APA's Response to DoP SUMMARY OF PUBLIC SUBMISSIONS

RESIDENTIAL SUBDIVISION
AT LOT 171 DP 1081810 HIGHVIEW DRIVE, DOLPHIN POINT

PLAN SHOWING PROJECT APPLICATION FOR FAUNA RECORDS OF LOT 171 DP1081810 AT HIGHVIEW DRIVE, DOLPHIN POINT FOR MALBEC PTY LTD

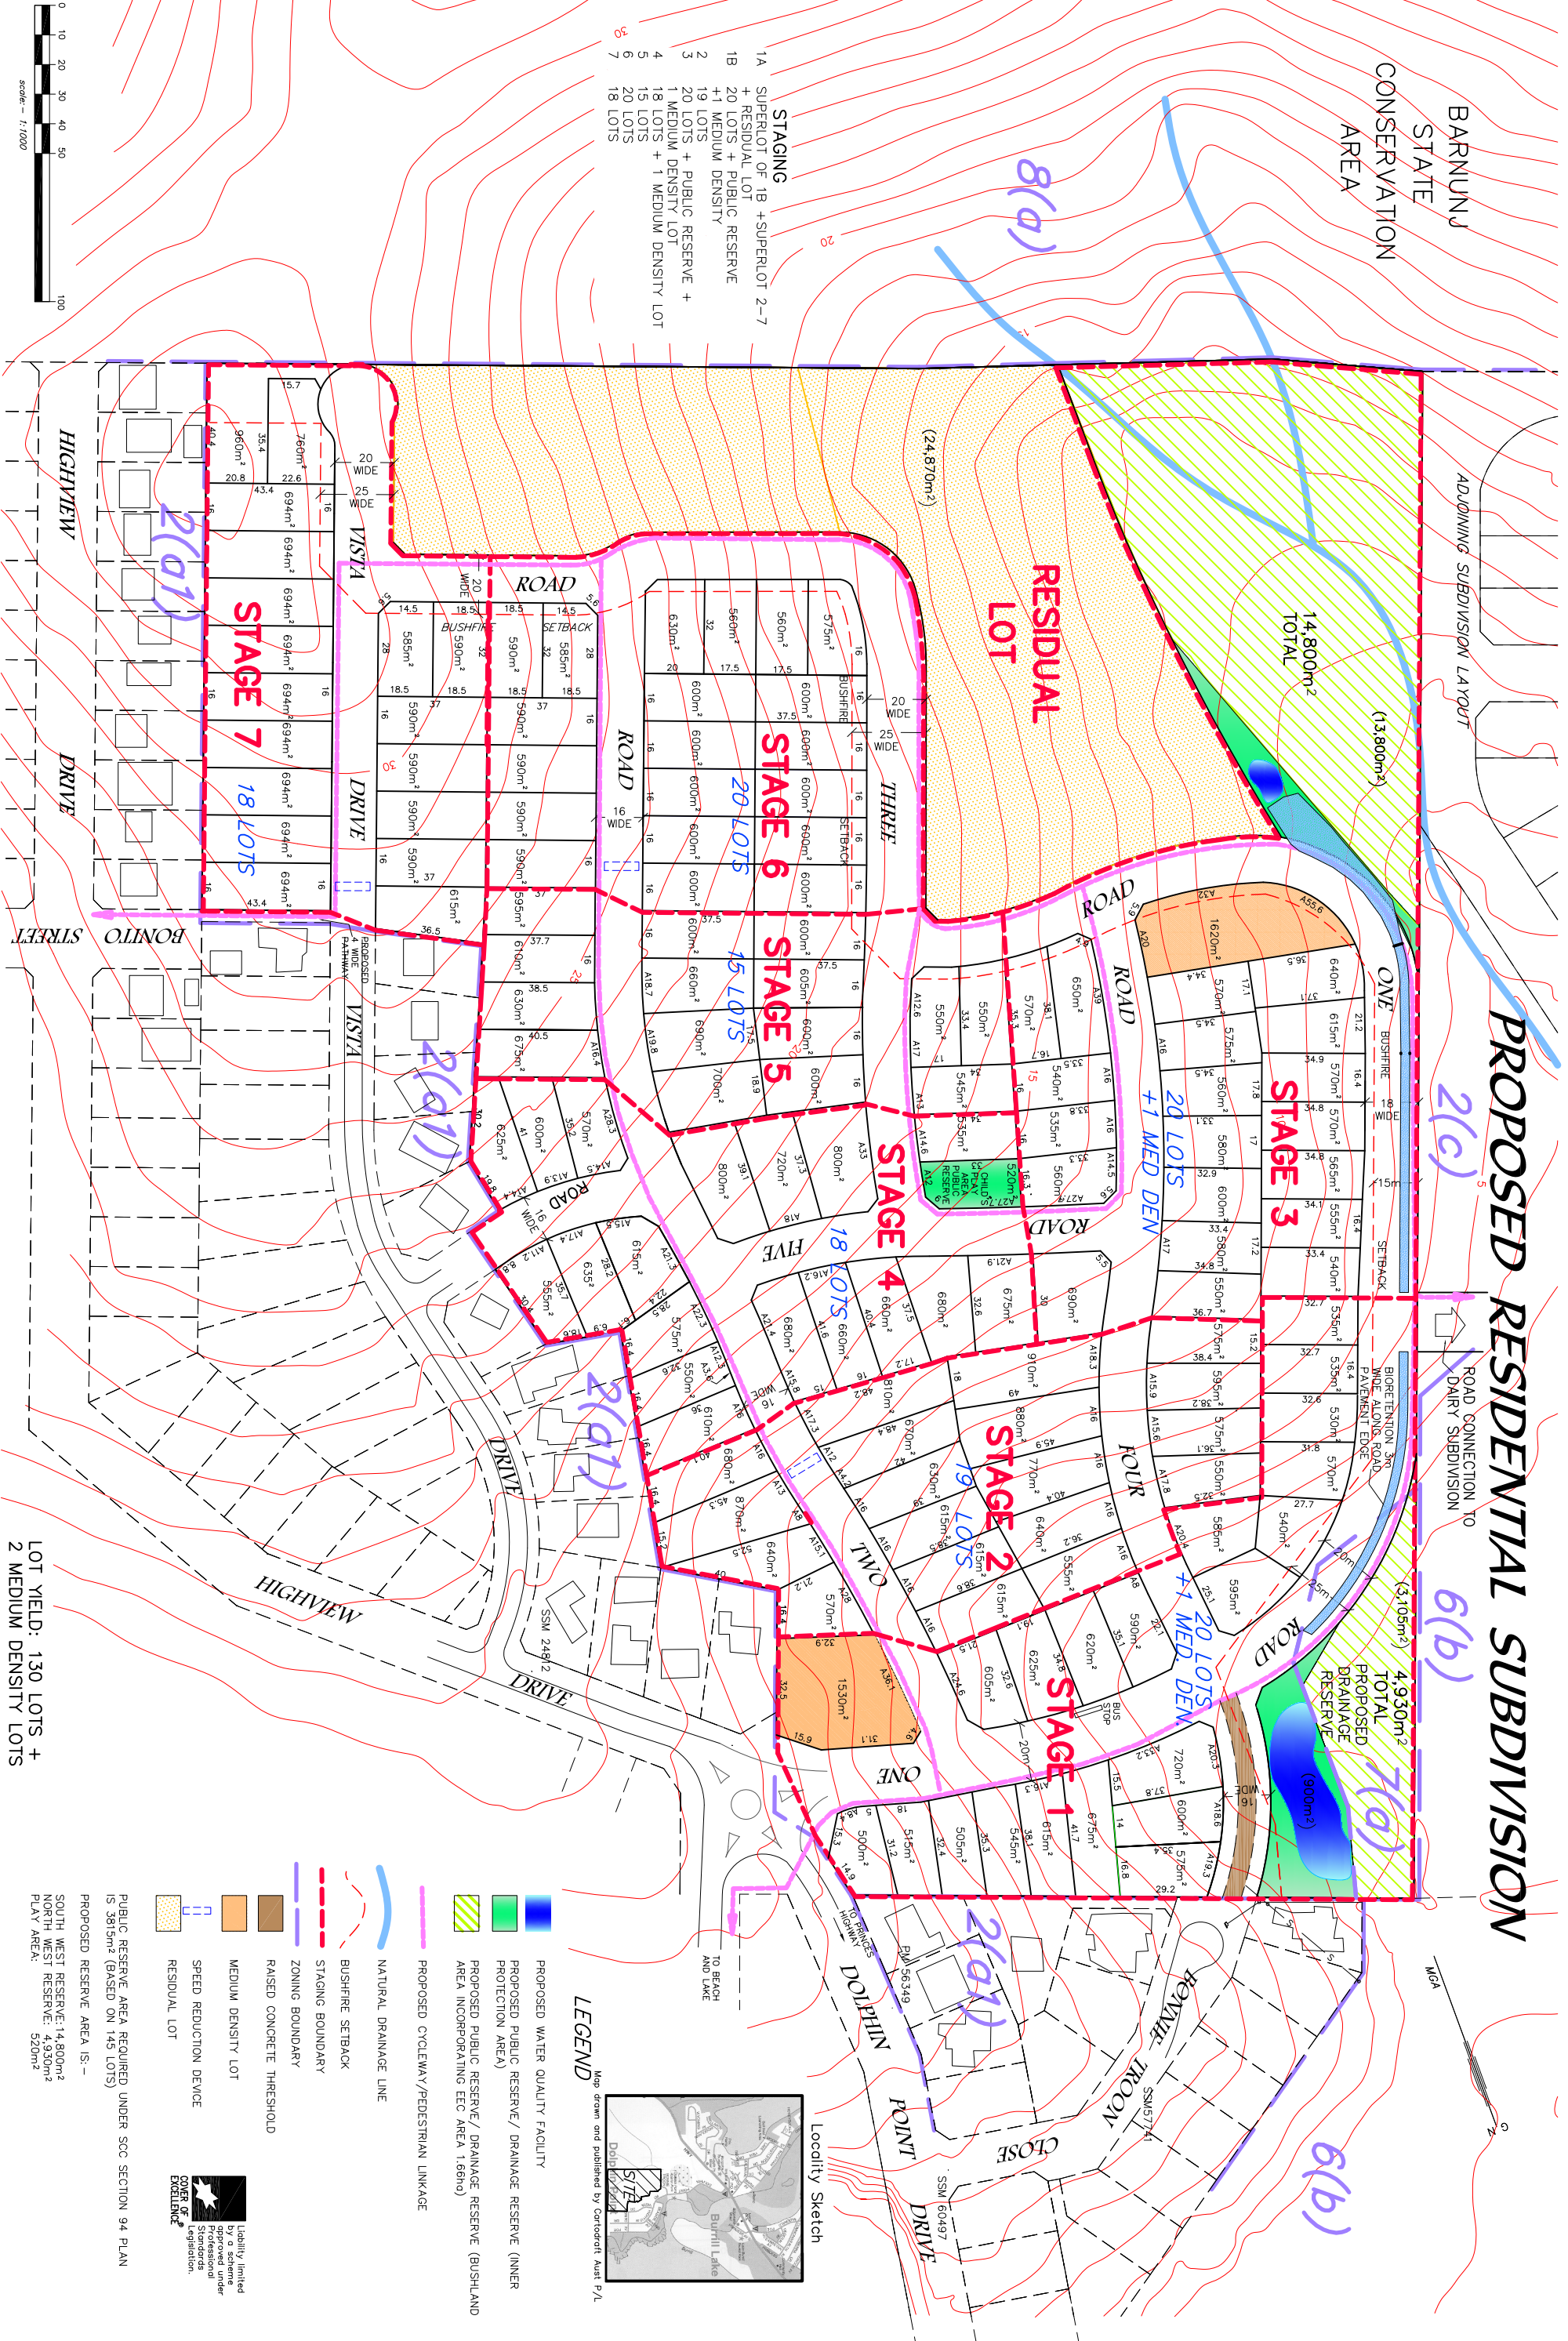
1	Raised potential of making 'road 8' a reverse cul-de-sac to BTC or adding other traffic calming measures to alleviate traffic impacts.	Shoalhaven City Council's Planning Policy #1 (SPP1) anticipated an extension of Bonnie Troon Close. SPP1 was publicly exhibited and adopted by Council on 23 November 2004.
	2	Concern that BTC was always intended to be a cul-de-sac and not be a through road.	As stated earlier, it is proposed to construct a raised concrete threshold with layback kerb at both ends to discourage through traffic from using this road. See comments above.
	1	Concern on the cumulative traffic impacts on BTC from adjoining development proposal.	See comments above.

6. Design	1	Concern with the future built form on the site and its appropriateness for the area.	The proposed Design Guidelines will require coastal style homes to be constructed in accordance with Council's existing policies.
	1	Concern that one site is nominated for medium density which seems out of character with the current Dolphin Point village.	The existing zoning adopted by Council and State Government is a flexible residential zone that allows medium density. The proponent has been advised by DoP to provide the medium density sites.
